RIBBLE VALLEY
BOROUGH COUNCIL

Application for Planning Permission.
Town and Country Planning Act 1990

From: Louise Blatchford
Sent: 14 September 2011 16:58
To: 'Jon Hadfield'
Cc: Lesley Lund
Subject: Planning application - barn opposite Cold Coates Farm, Collins Hill Lane, Chipping

RE: Change of use of agricultural barn into two residential units
 AT: Barn opposite Cold Coates Farm, Collins Hill Lane, Chipping

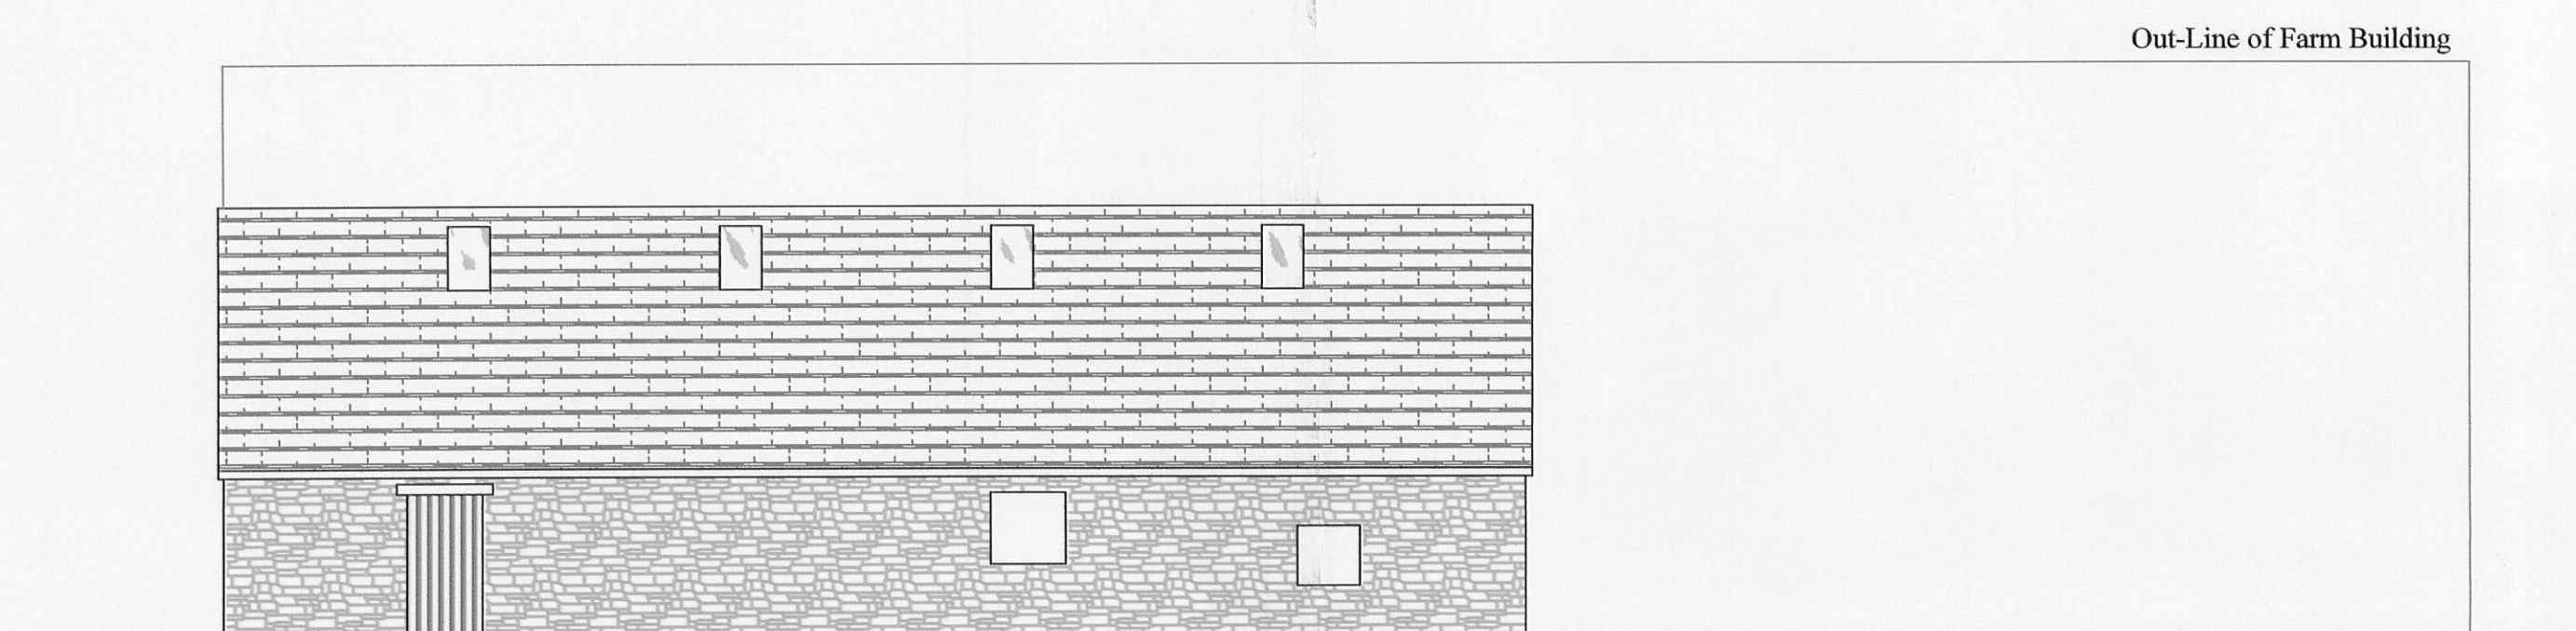
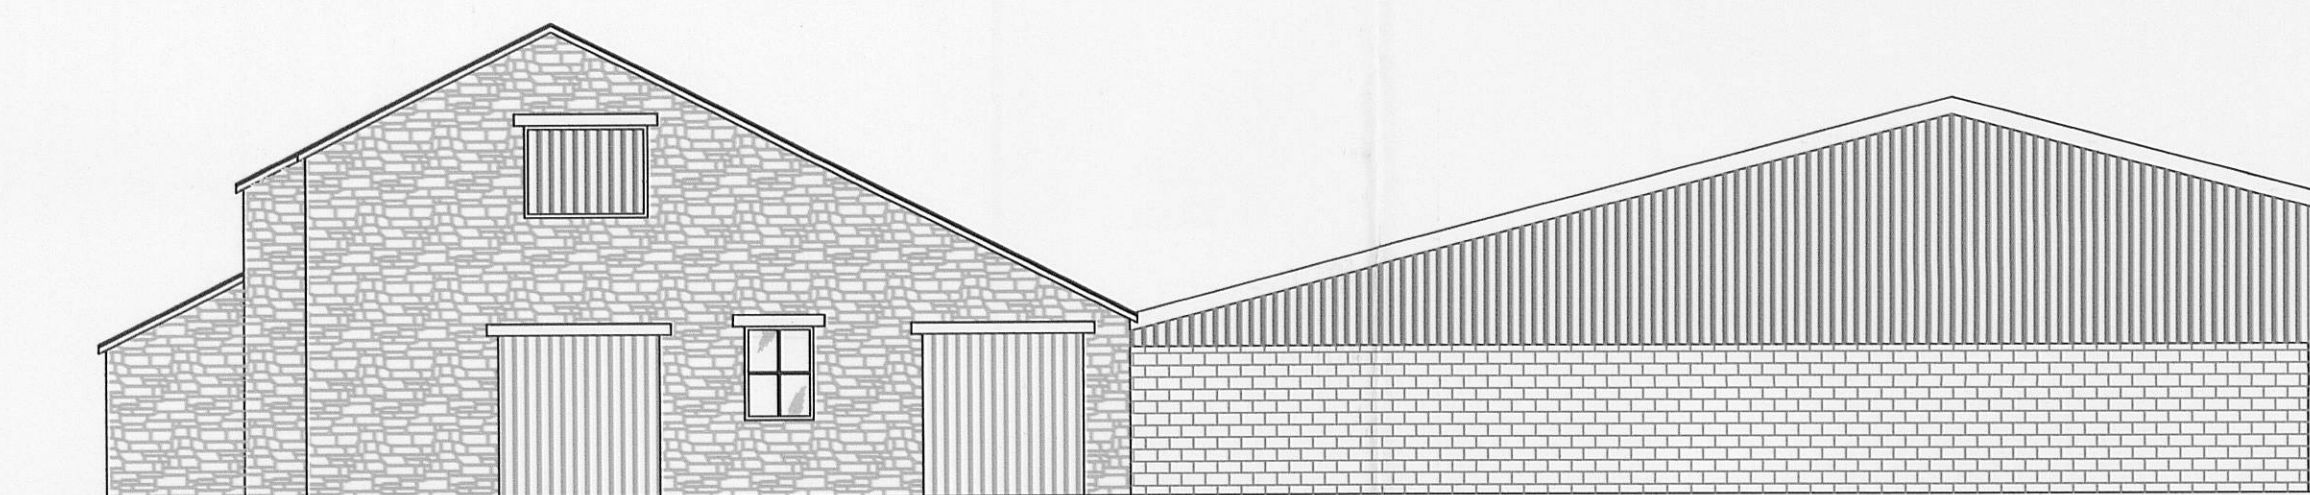
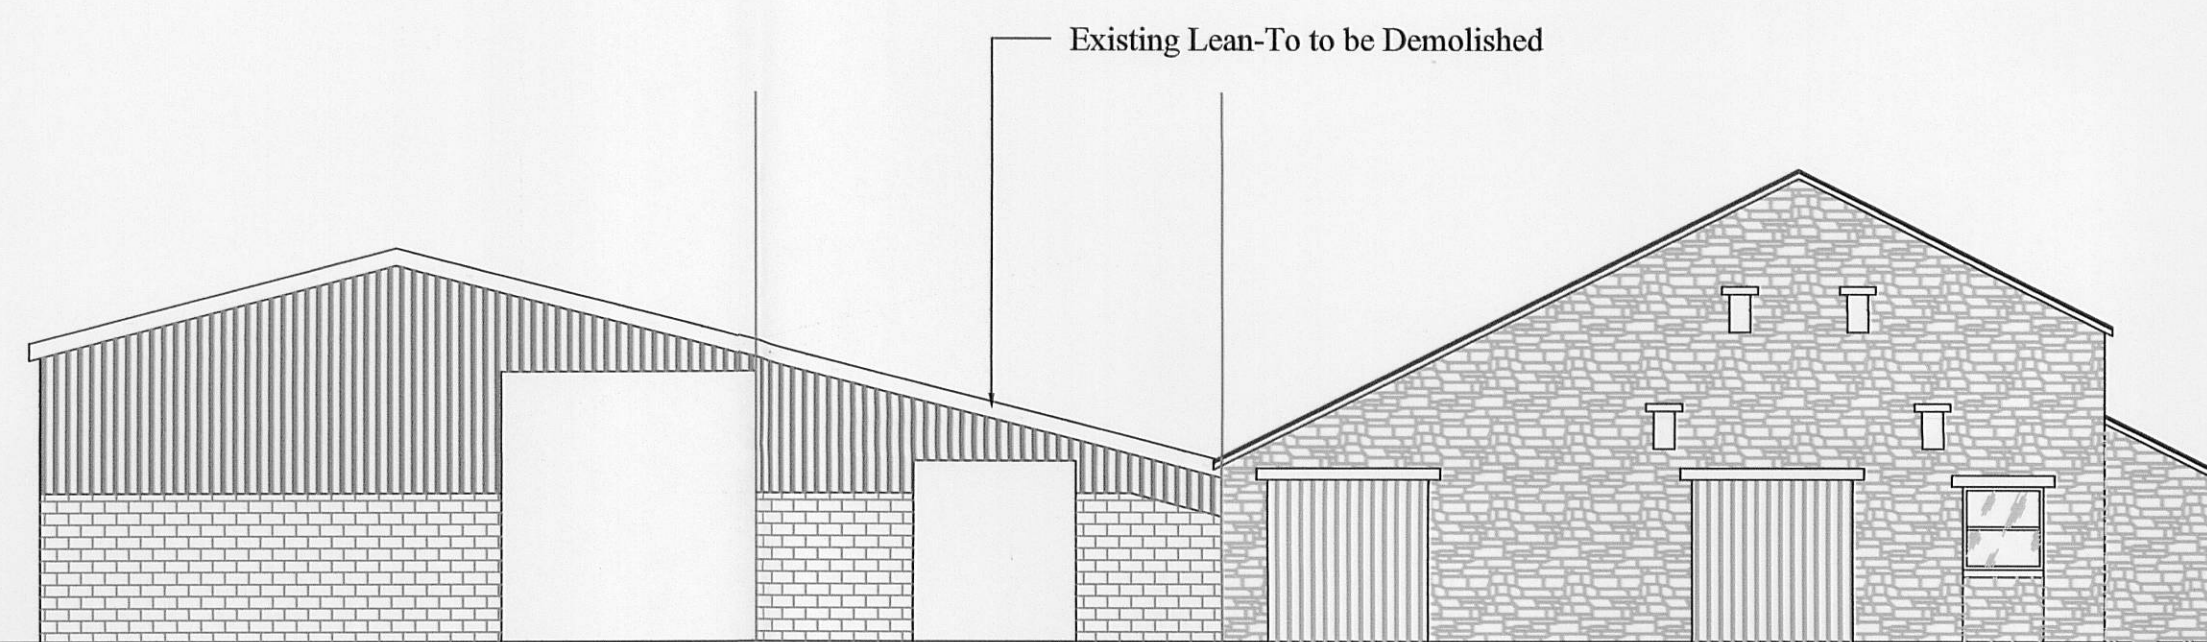
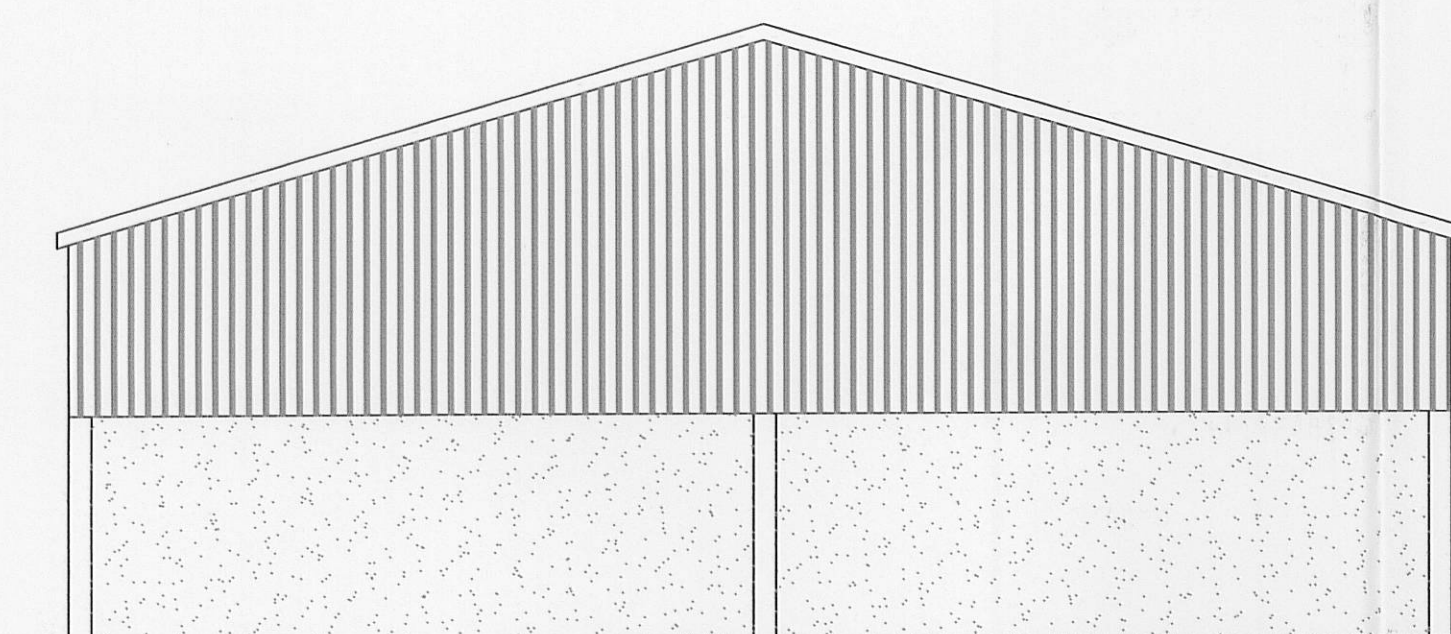
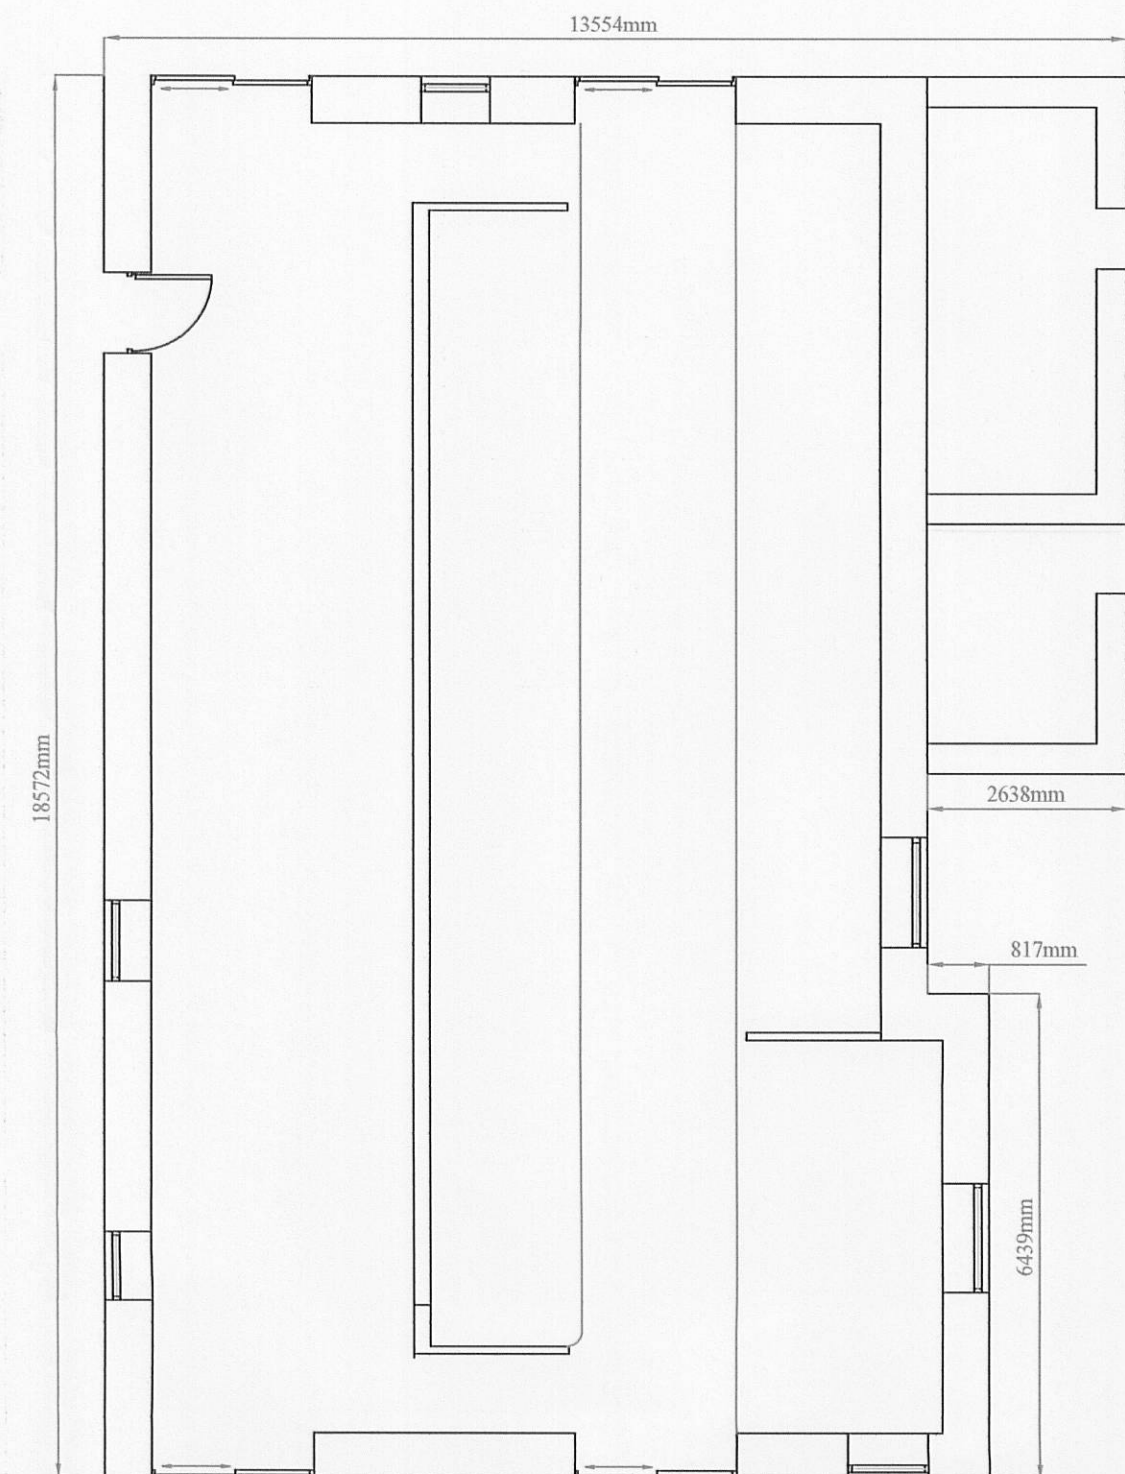
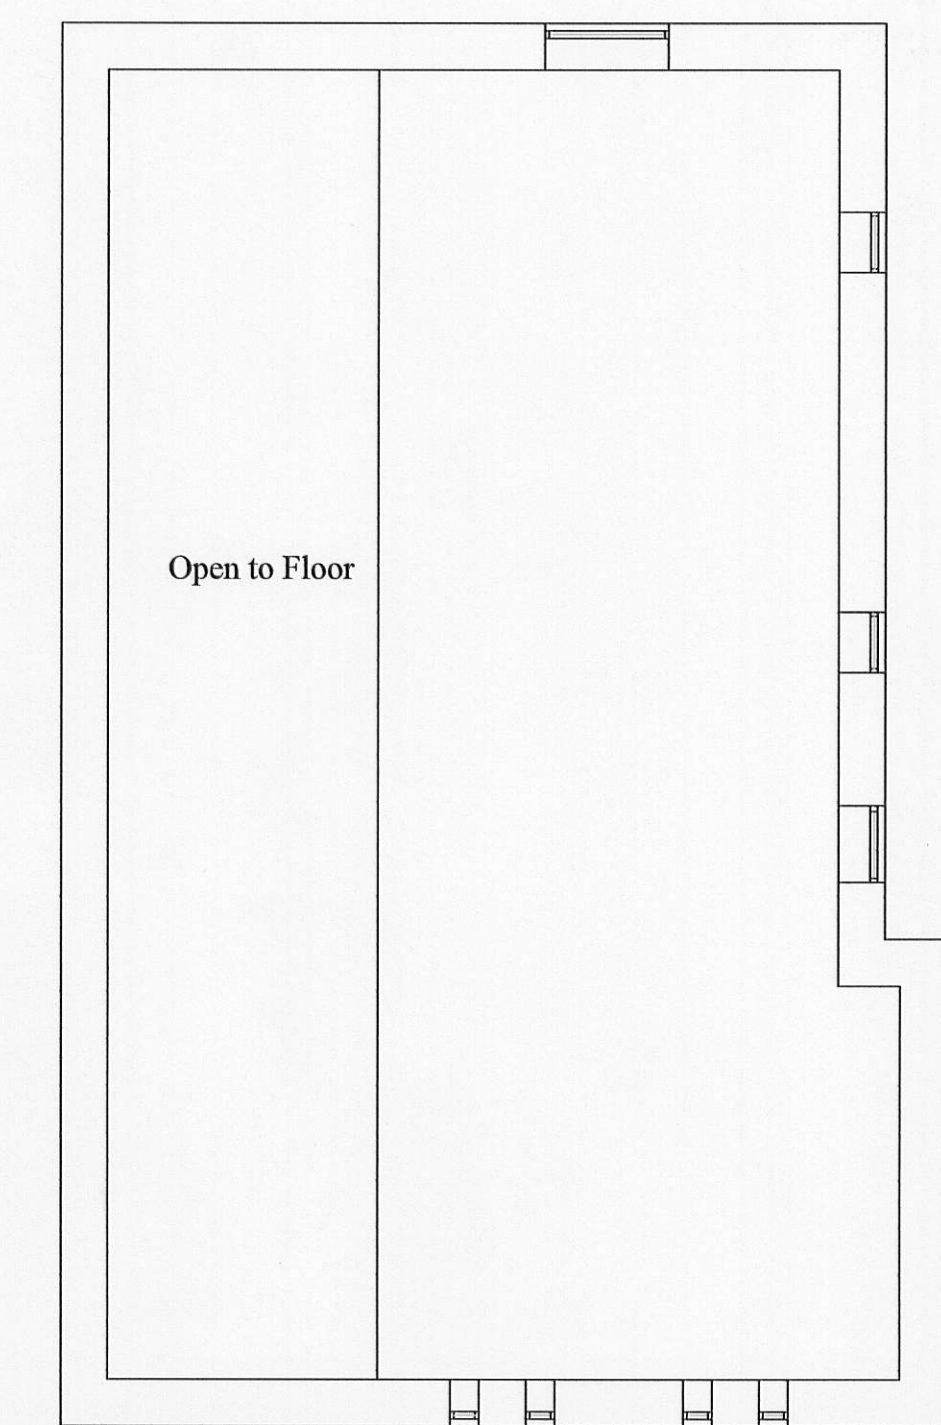
- There are differences in the existing and proposed plans in relation to openings not corresponding between the plans and also an incorrect elevation title - please can you call in to sort out.
